Application No: K/23/21/HH
Site Address: Mimosas Gorse Avenue East Preston BN16 1SF
Description of works: Erection of part 2 storey and single storey rear extension and first floor balcony

Thank you for your internet representation made on 17th June 2021 which has been recorded as an objection with the comments as follows:

Kingston Parish Council would like to make the below observations:

Existing survey
was undertaken
by others
including heights

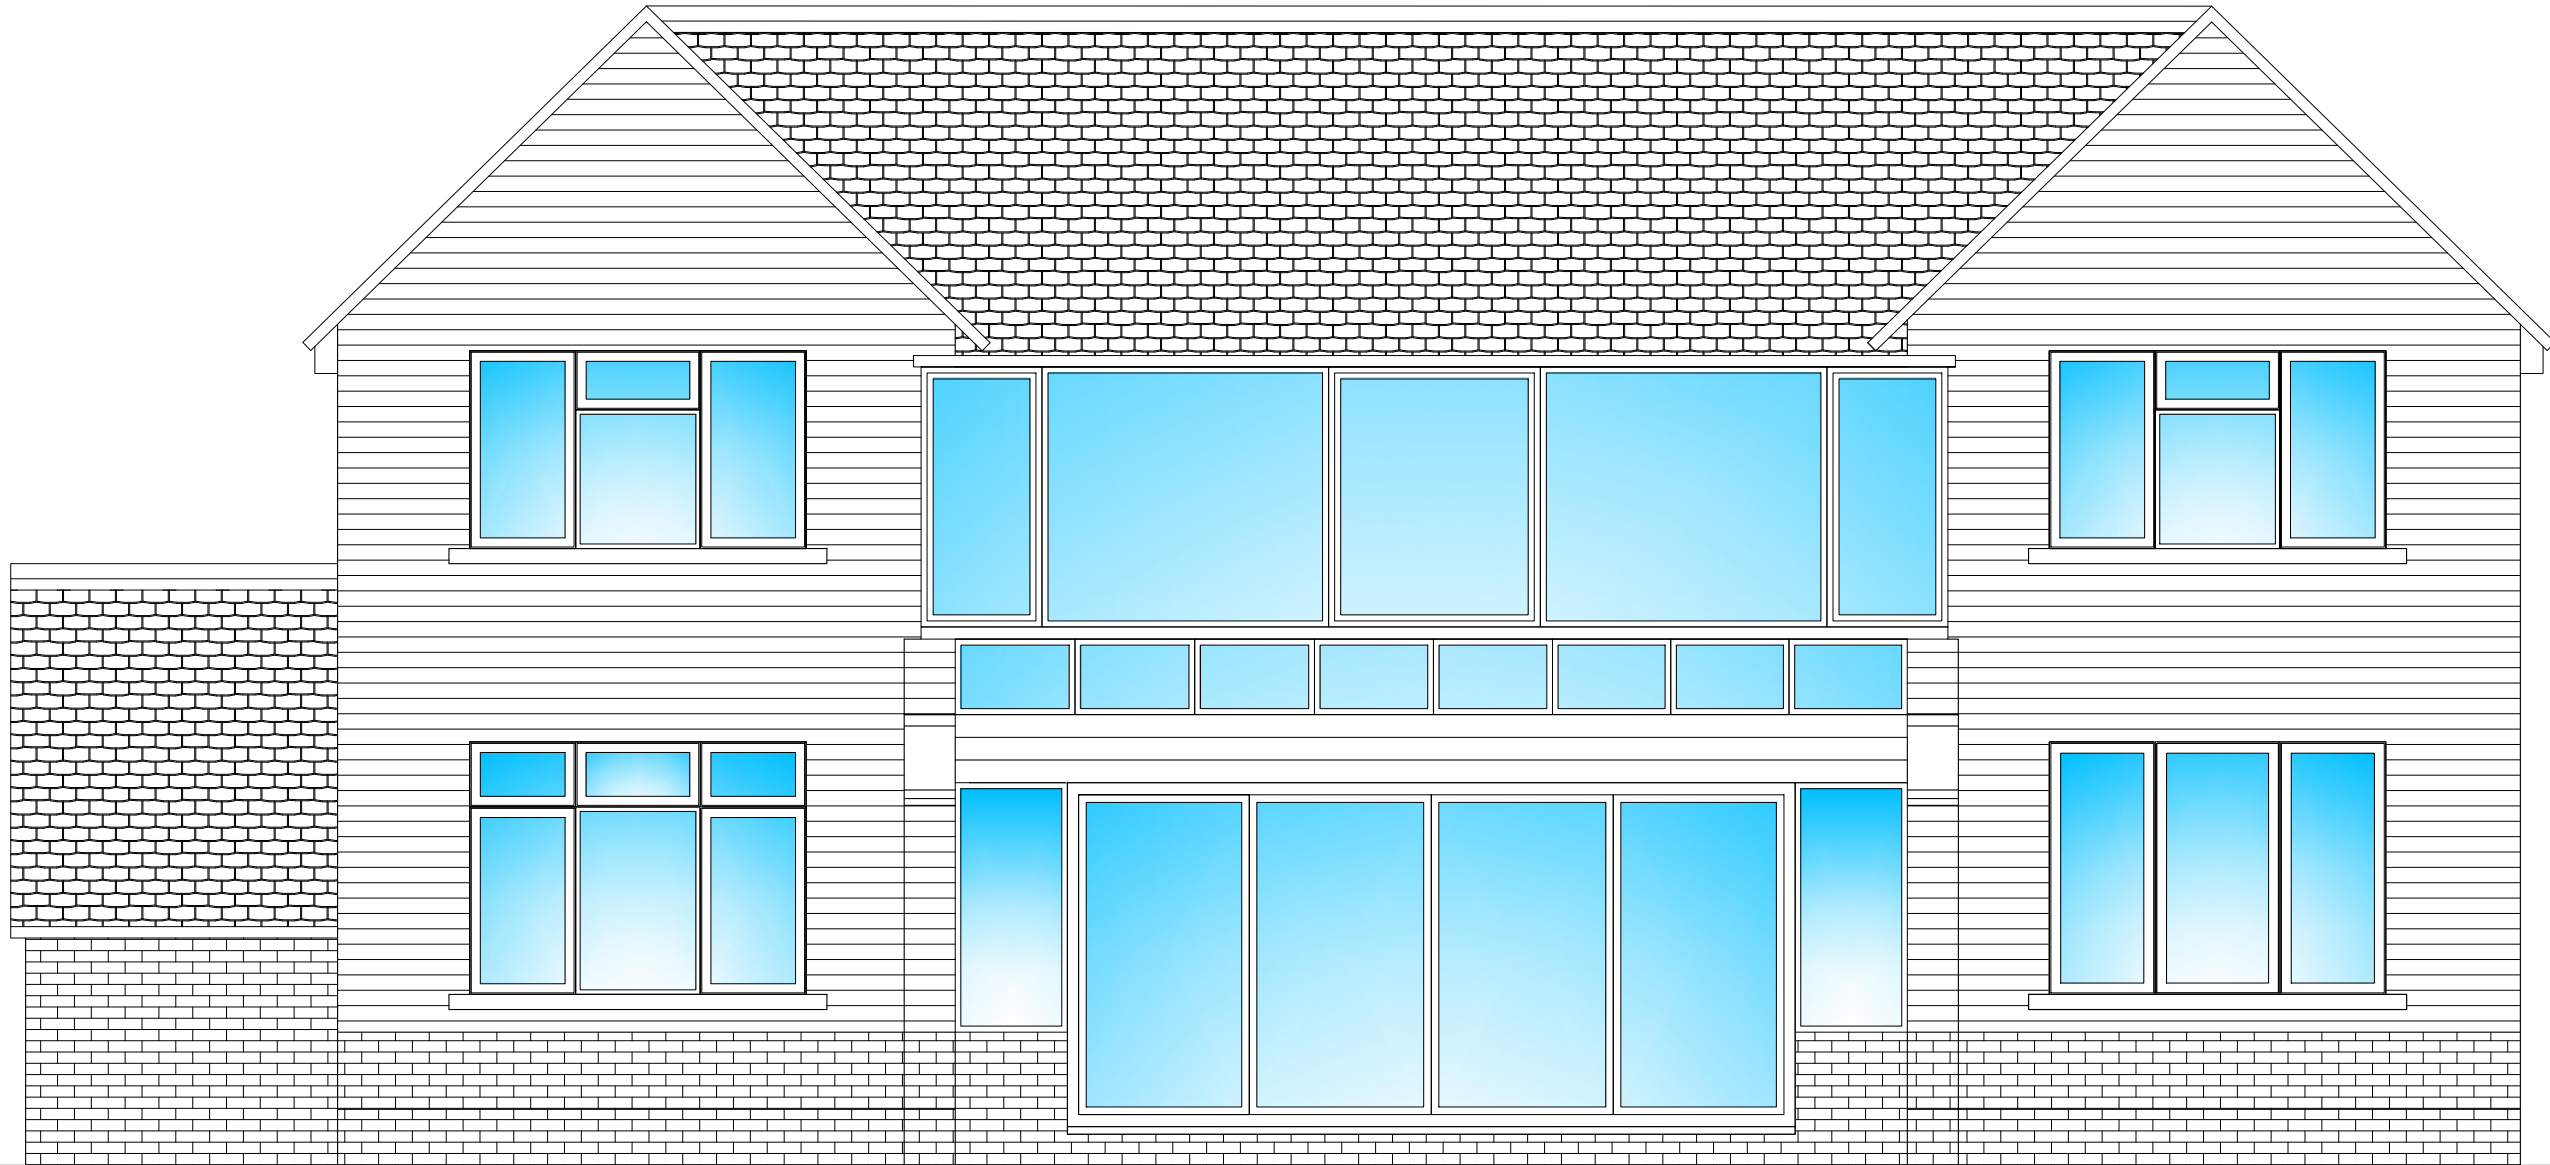
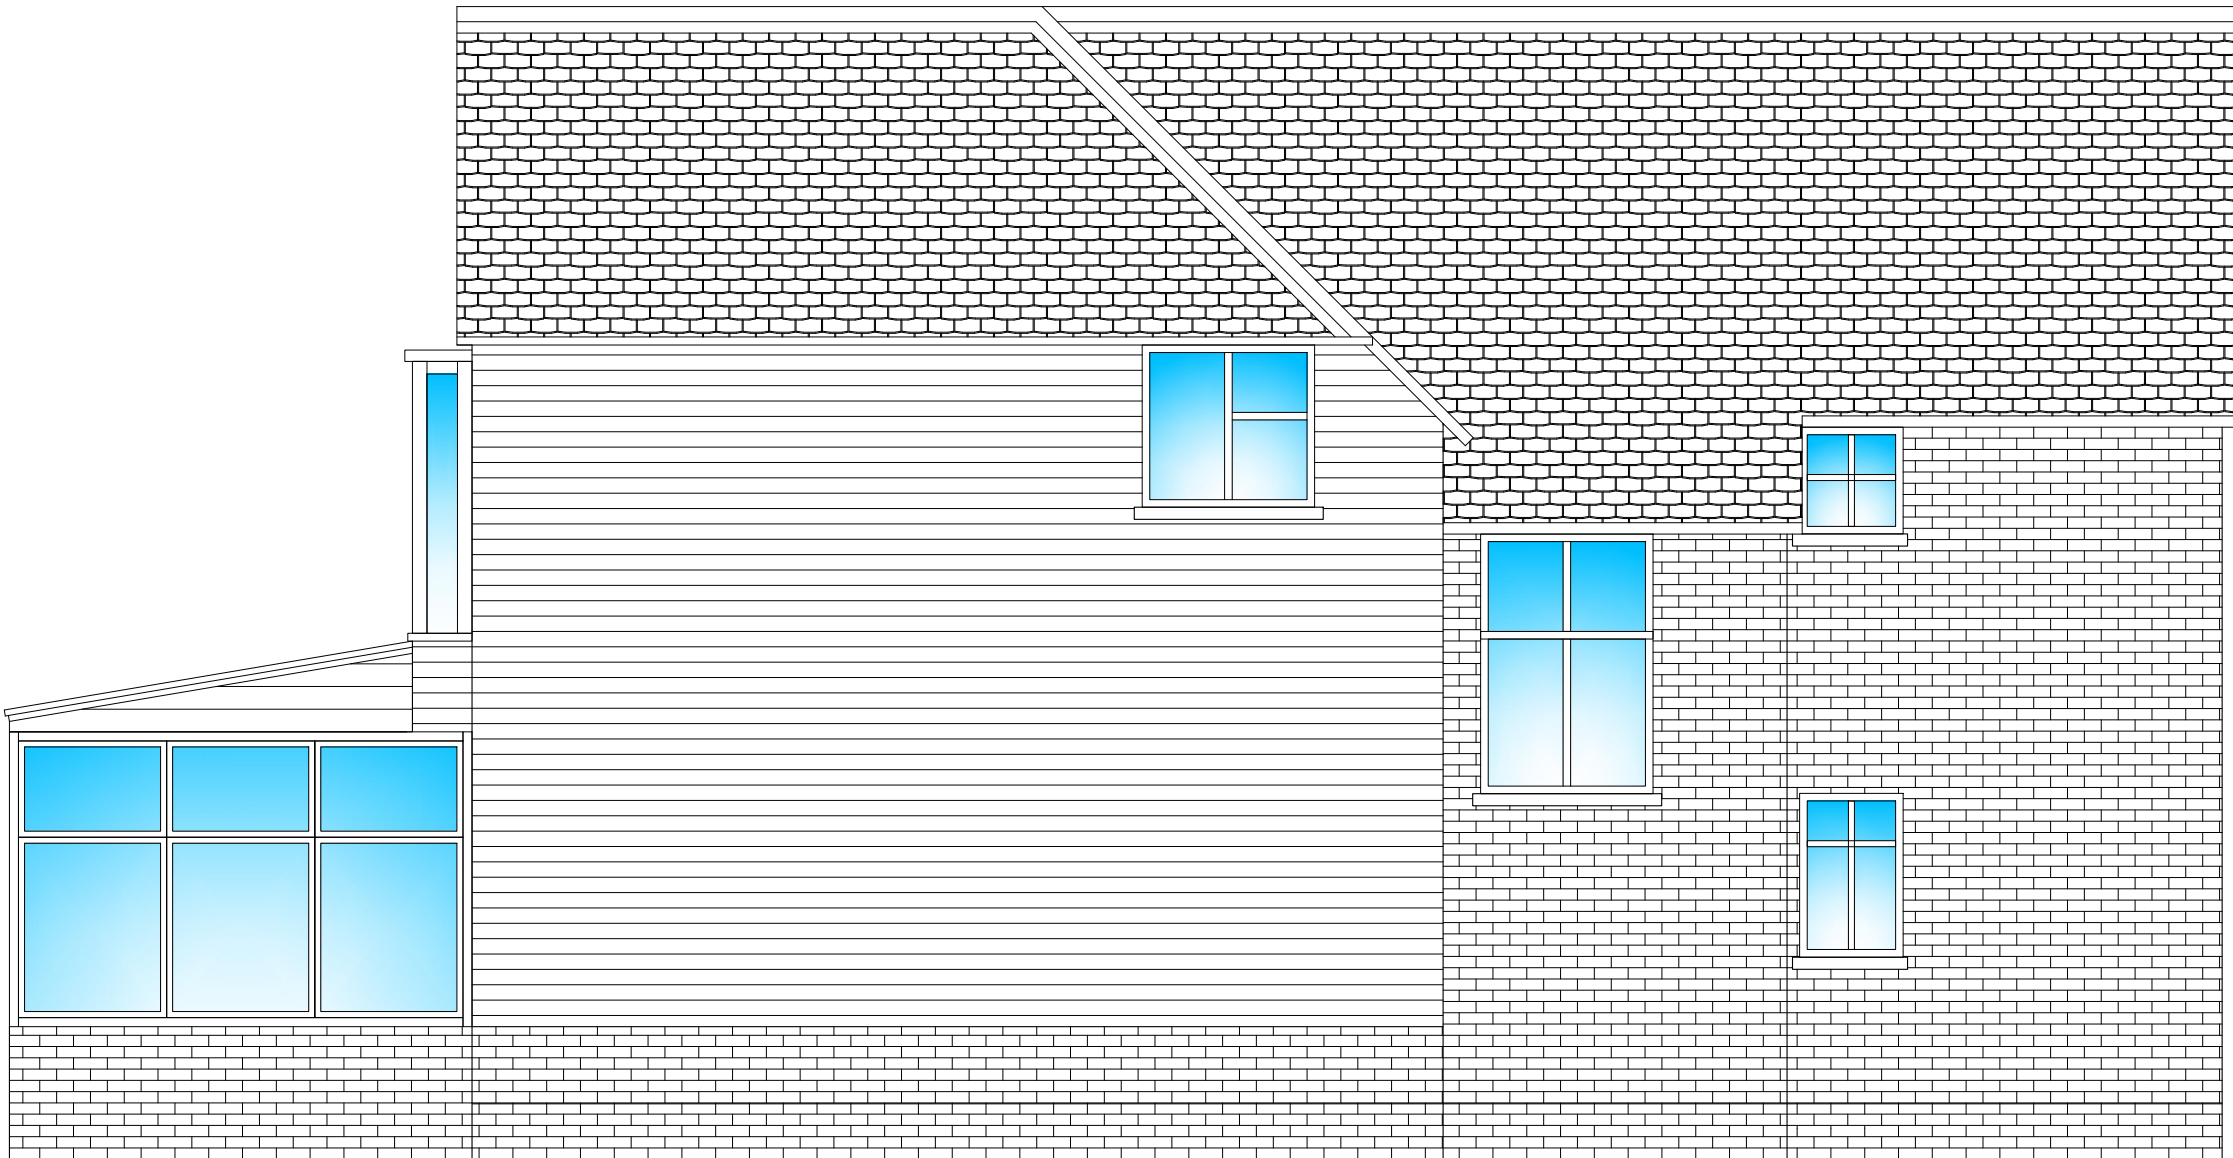
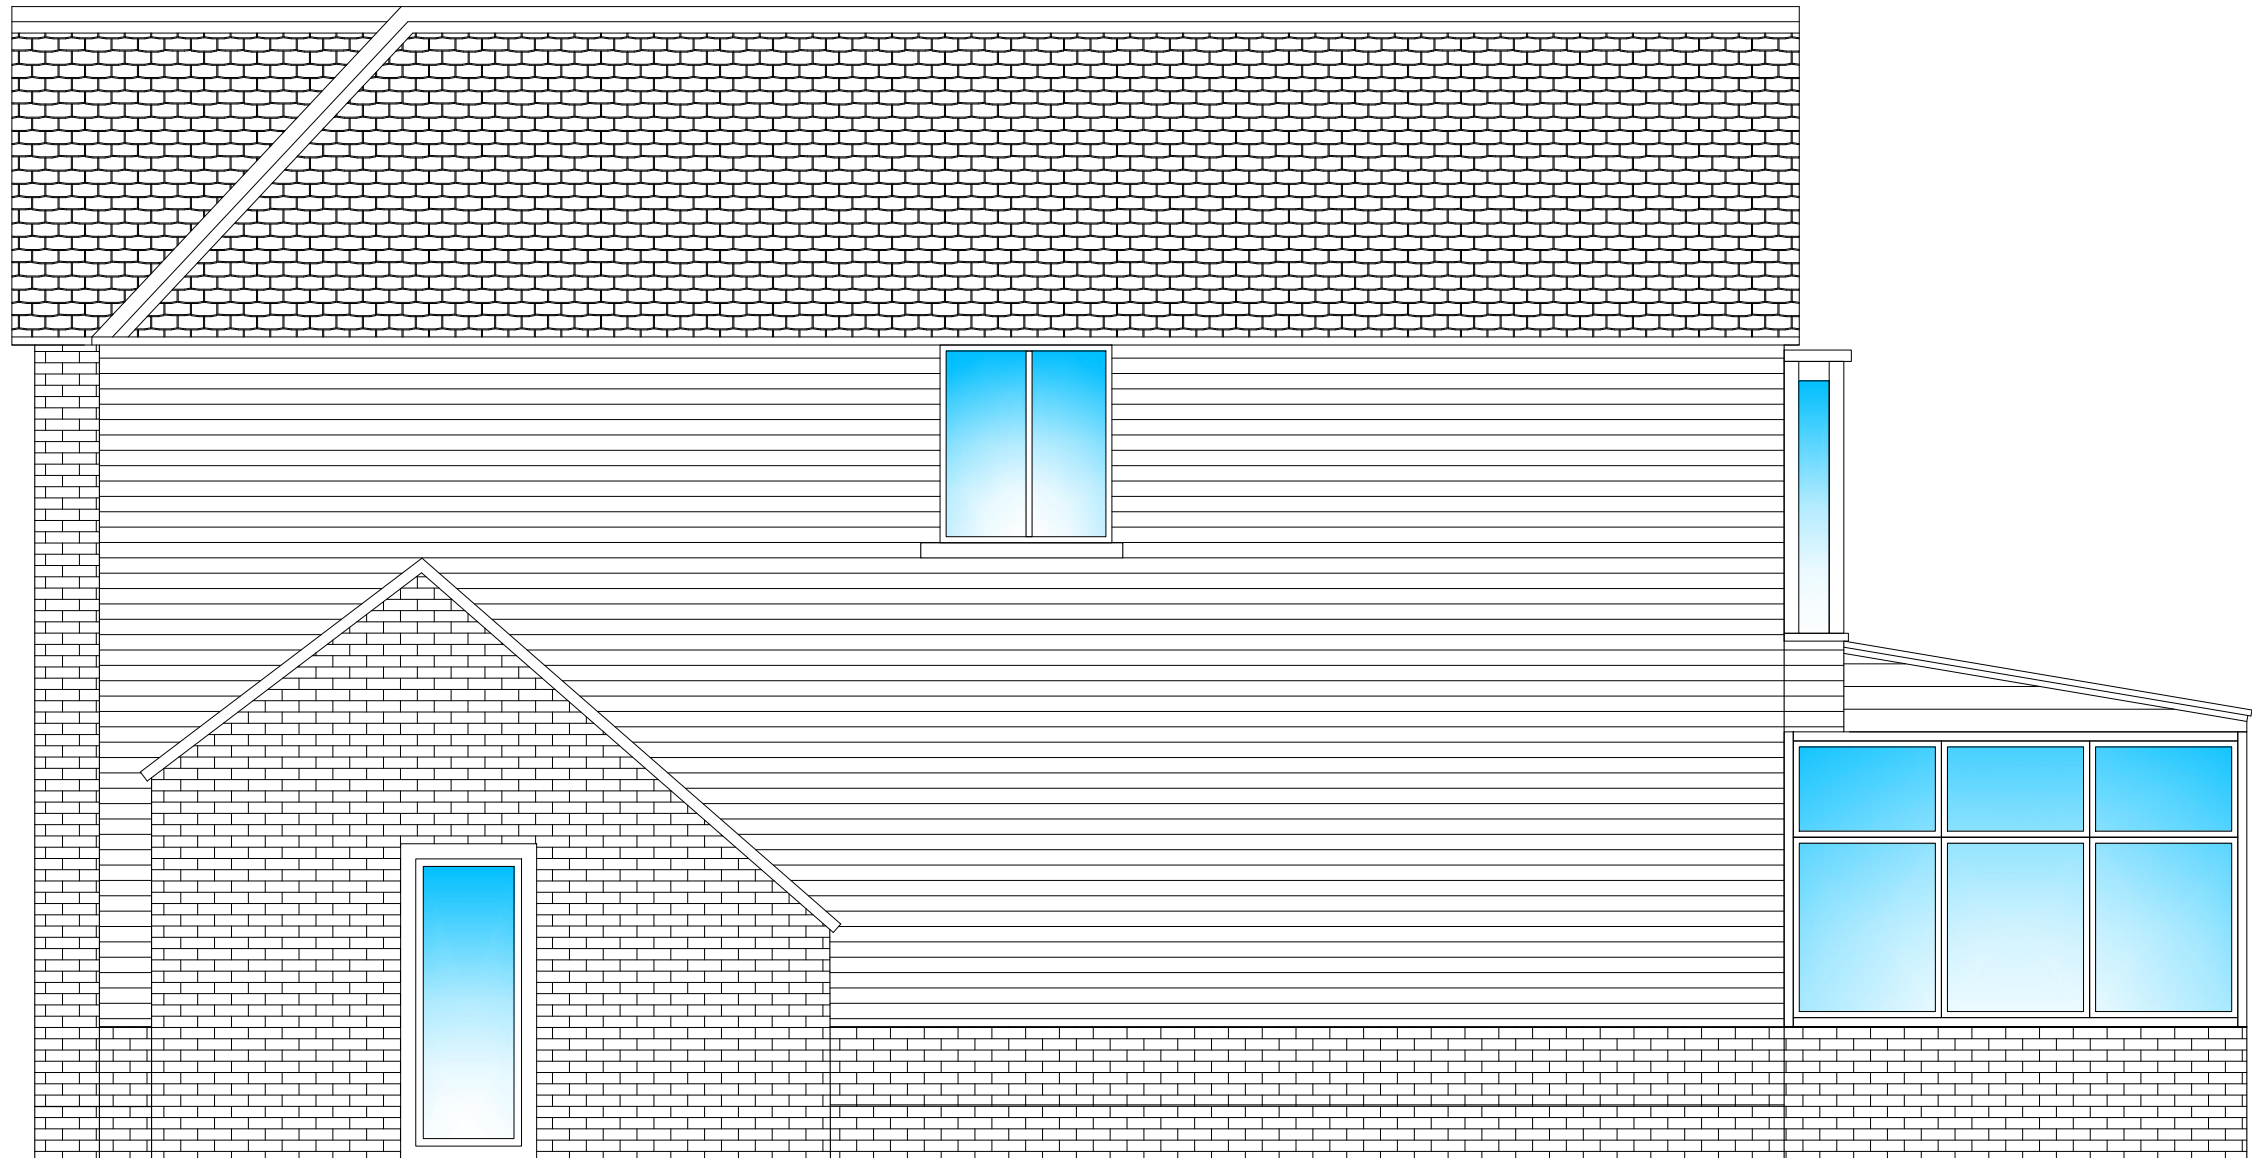
- Ridge height - the ridge height of the new extension is considerably higher than the original, but there are no heights given for the elevations, only the comment "existing survey was undertaken by others, including heights". rough calculations put it higher by nearly 1 metre (900 mm / 35 inches) to the original roof.
- Spring Tide could be overlooked from the new balcony.
